EL PASO COUNTY PARKS DEPARTMENT | PARK PLANNING DIVISION

January 14, 2026

Subject: The Triple H Ranch Preliminary Plan (SP-25-004)

TRIPLE H RANCH
PRELIMINARY PLAN

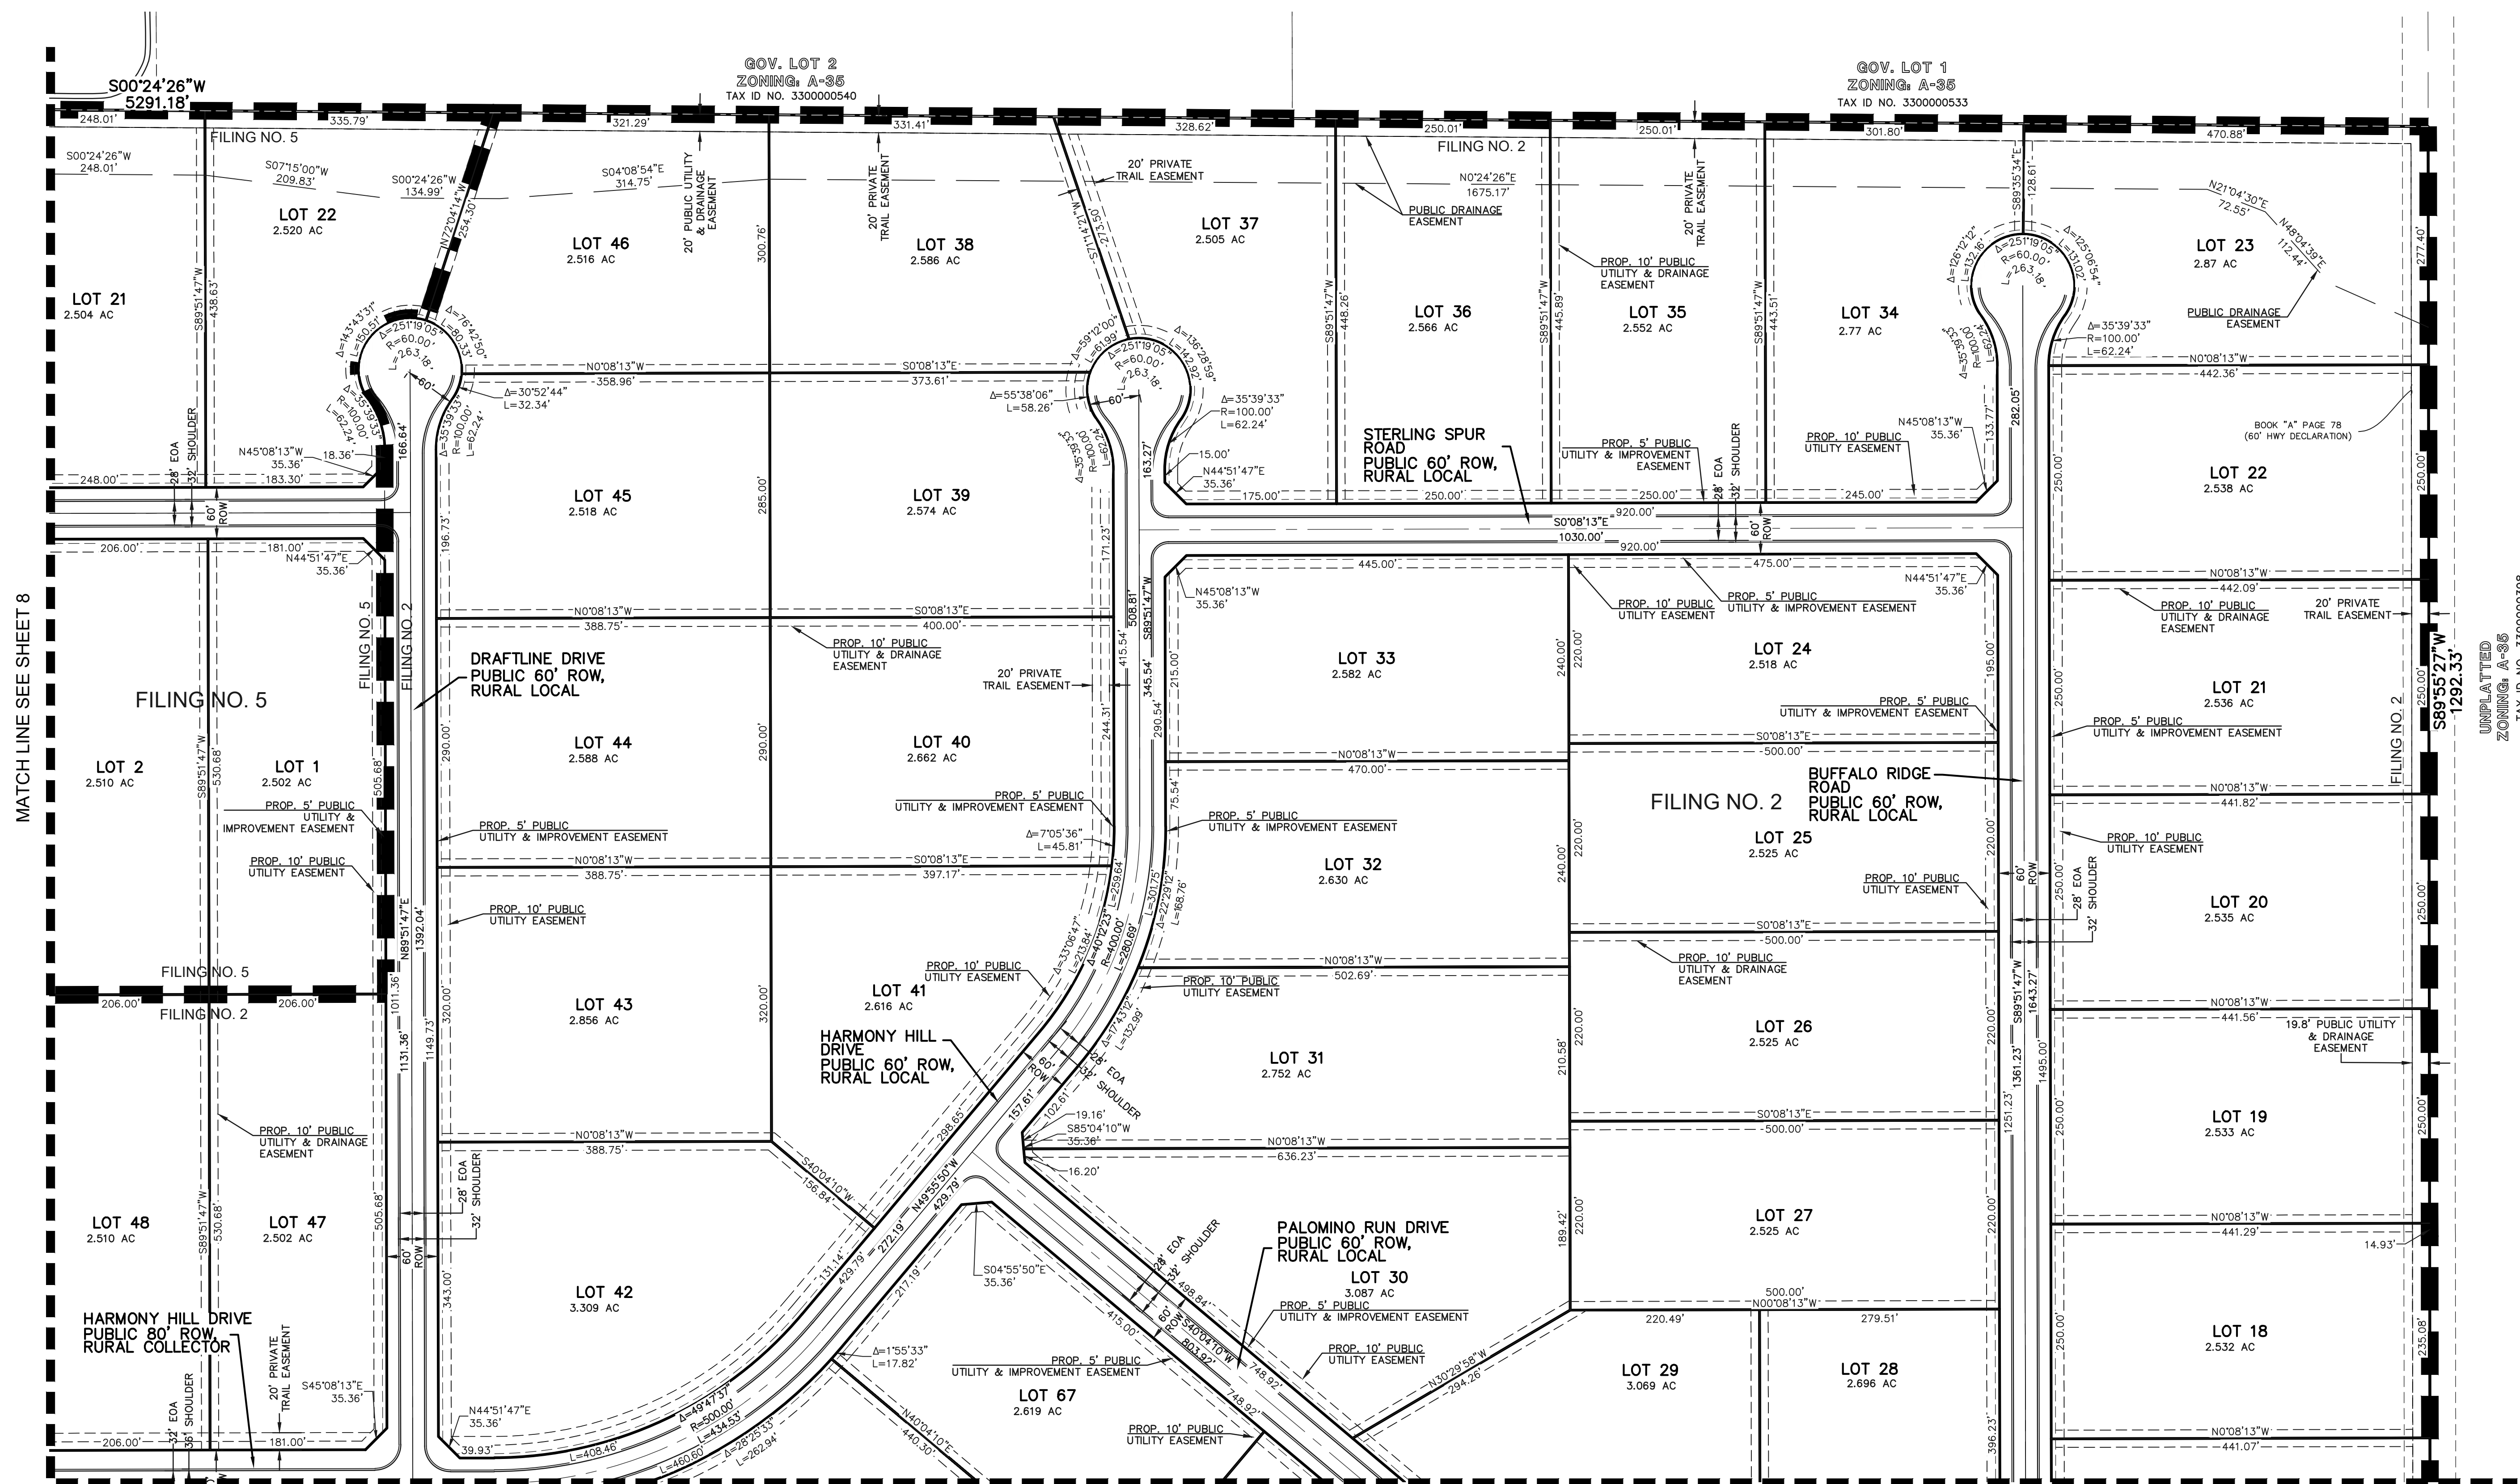
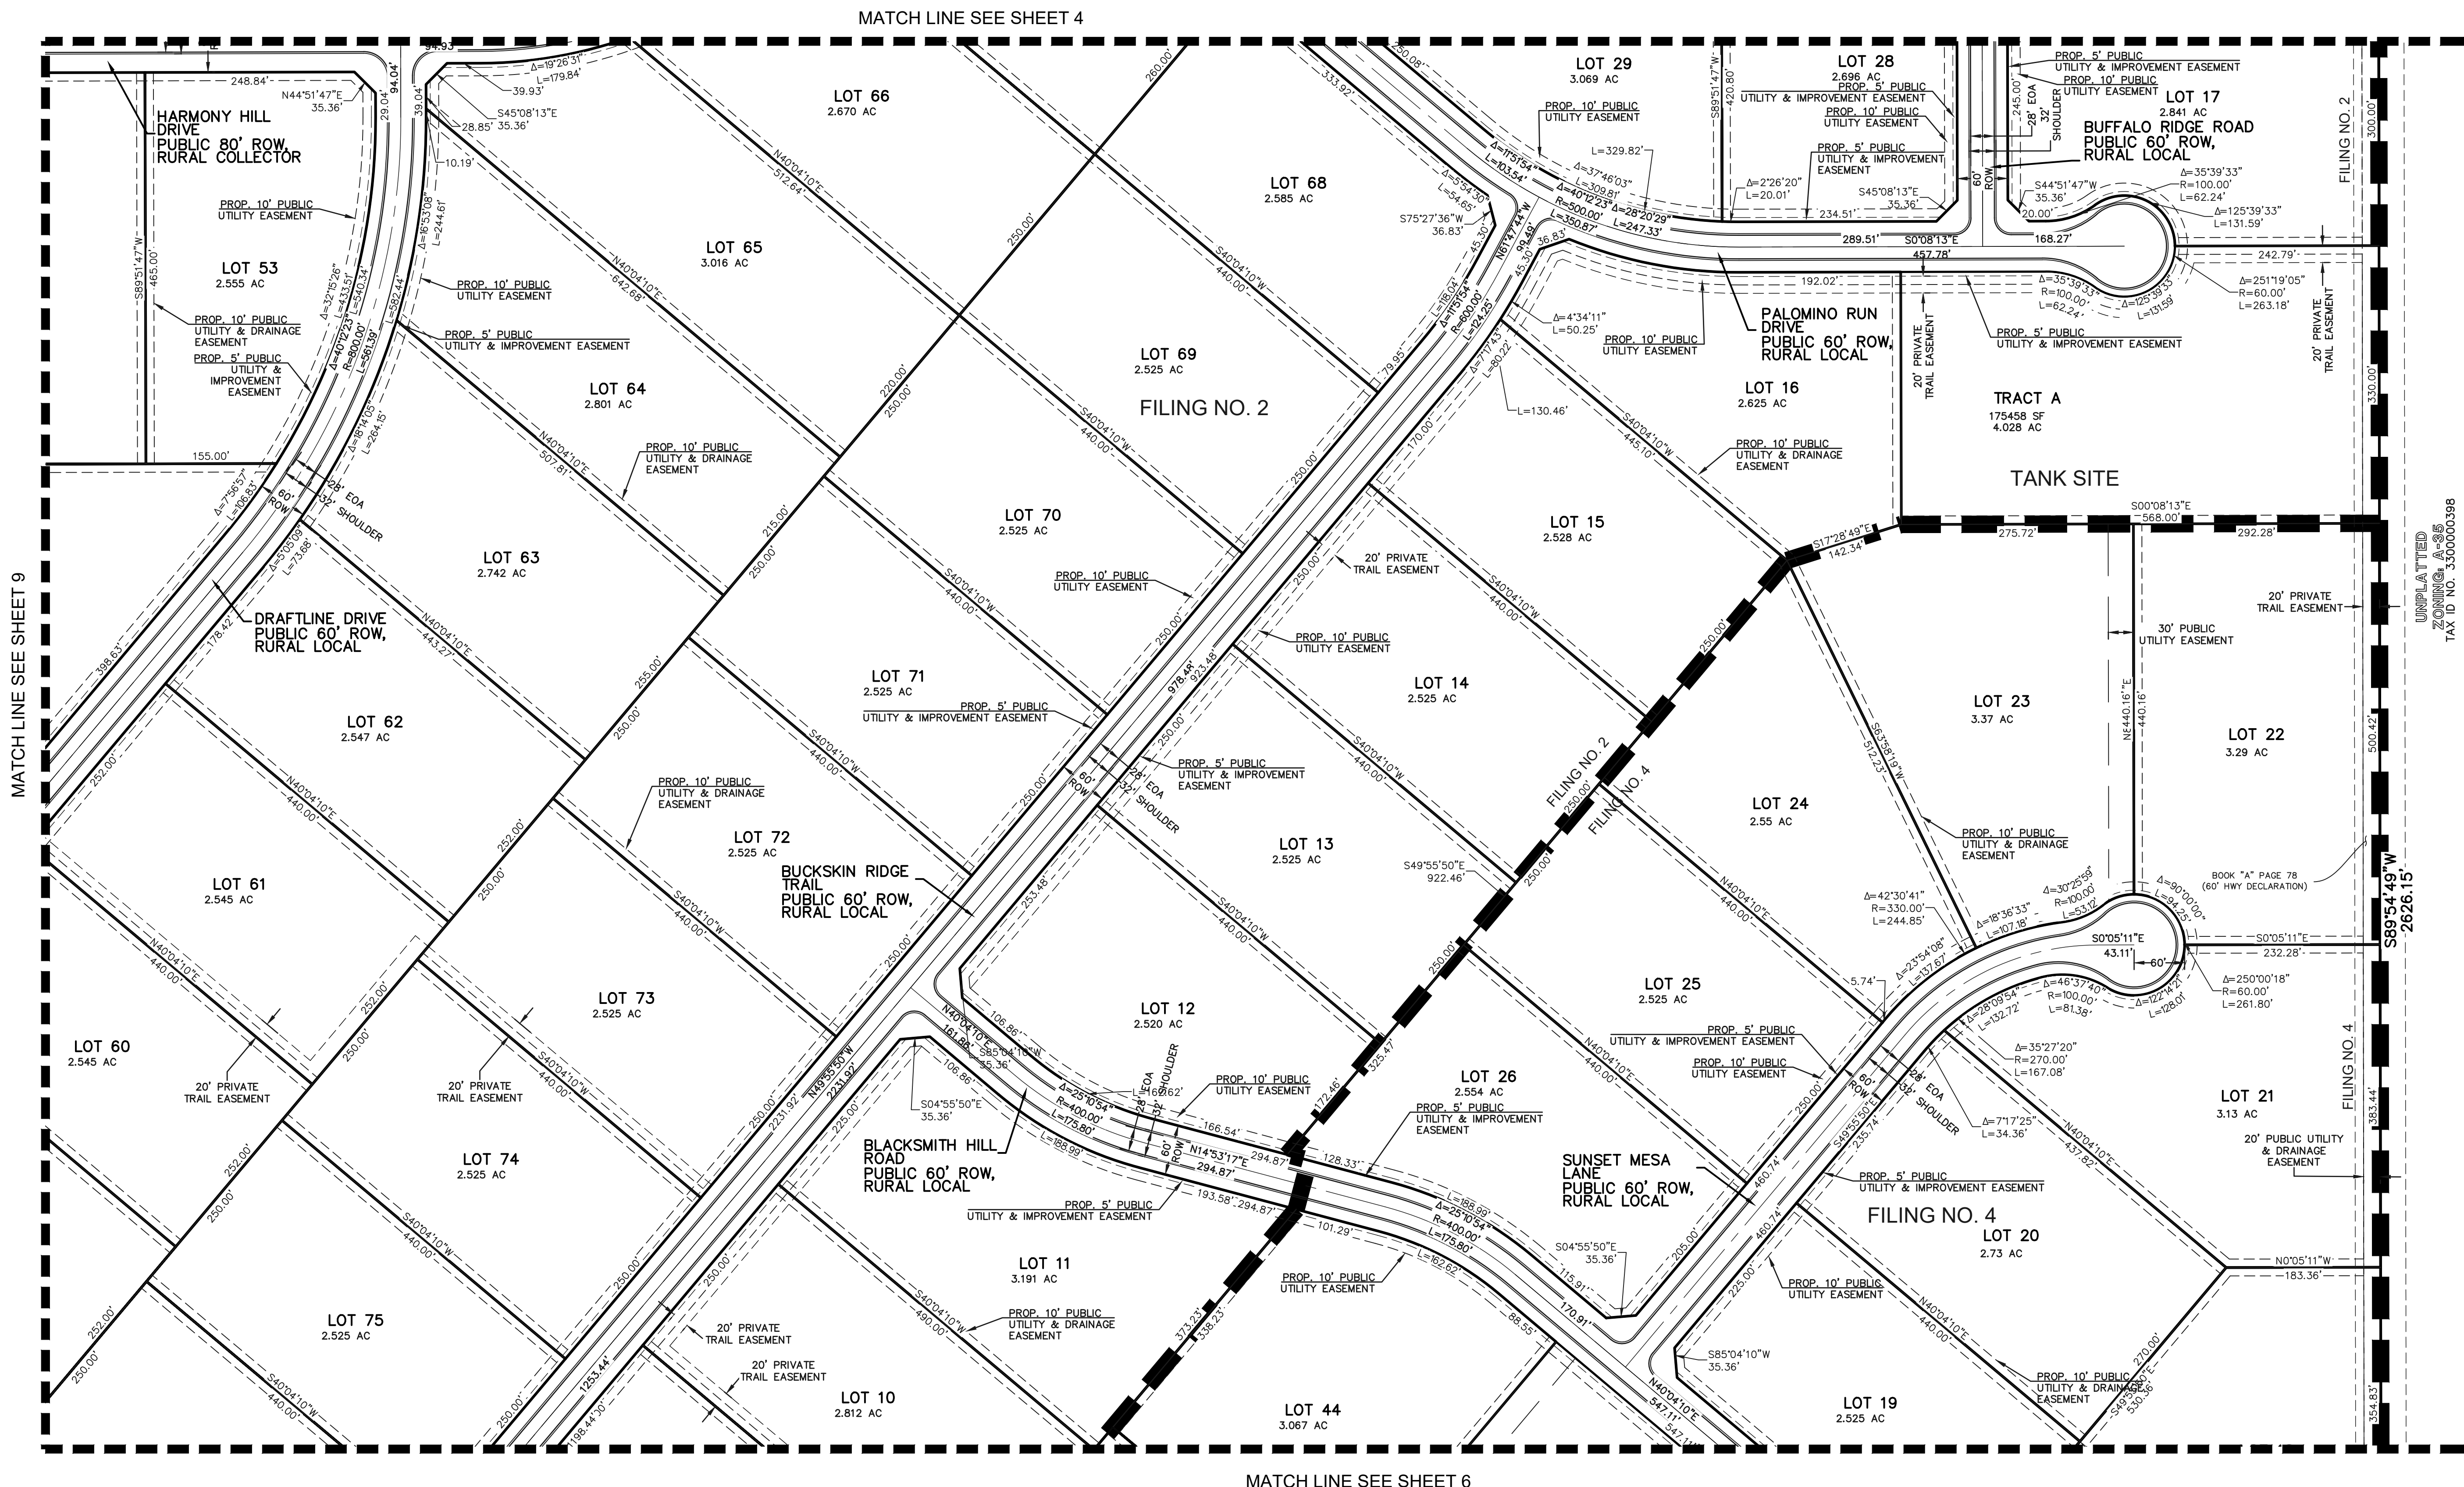
El Paso County Parks staff is pleased to see the applicant's willingness to provide open space tracts, two neighborhood park sites, and trail corridors. Upon review of the preliminary plan drawings, Parks staff noticed that the drawings do not clearly identify proposed county vs. non-county trails. Parks staff is requesting the applicant update and revise the preliminary plan to clearly delineate all trail easements and distinguish between county and non-county trails.

After reviewing the preliminary plan, staff met with the applicant to discuss the regional trail easement corridor along the southern boundary. Specifically, to discuss the alignment of the regional trail around an excluded parcel along Jones Road that would prevent a contiguous trail corridor. After discussion with the applicant, staff is recommending that two trail easements be secured as part of this application, with plat notes stating the County will only develop one alignment and relinquish the other. One easement will follow Jones Road and traverse the southwest corner of the project boundary, following the Parks Master Plan alignment. The second easement would include an alignment within the Triple H project boundary around the excluded parcel, generally along Harmony Hill Road, Appalossa Run Drive, Draftline Drive, and Heritage Hollow Road.

lieu of land dedication for regional park purposes in the amount of \$123,220. A Park Lands Agreement may be an acceptable alternative to required fees, provided the agreement is approved by the County prior to recording the future final plat(s). (2) Designate and provide to El Paso County 25-foot public trail easements along the southwestern boundary and the southern boundary of the Triple H Ranch Preliminary Plan along Jones Road, that allow for public access, as well as construction and maintenance by El Paso County for the Judge Orr Secondary Regional Trail, and the easements be shown, noted, and dedicated to the county via the forthcoming Final Plat(s) (3) Parks staff requests that the applicant designate and provide to El Paso County a 25-foot public trail easement following near Harmony Hill Road, Appaloosa Run Drive, Draftline Drive, and Heritage Hollow Road which are at the south end of the Triple H Ranch Preliminary Plan boundary. Staff recommends that El Paso County relinquish the trail easement if in the future it is no longer required and the master planned proposed trail can be obtained. (4) Parks staff is requesting the applicant update and revise the preliminary plan that clearly delineates all trail easements and explicitly distinguishes between County-maintained and non-County trails.
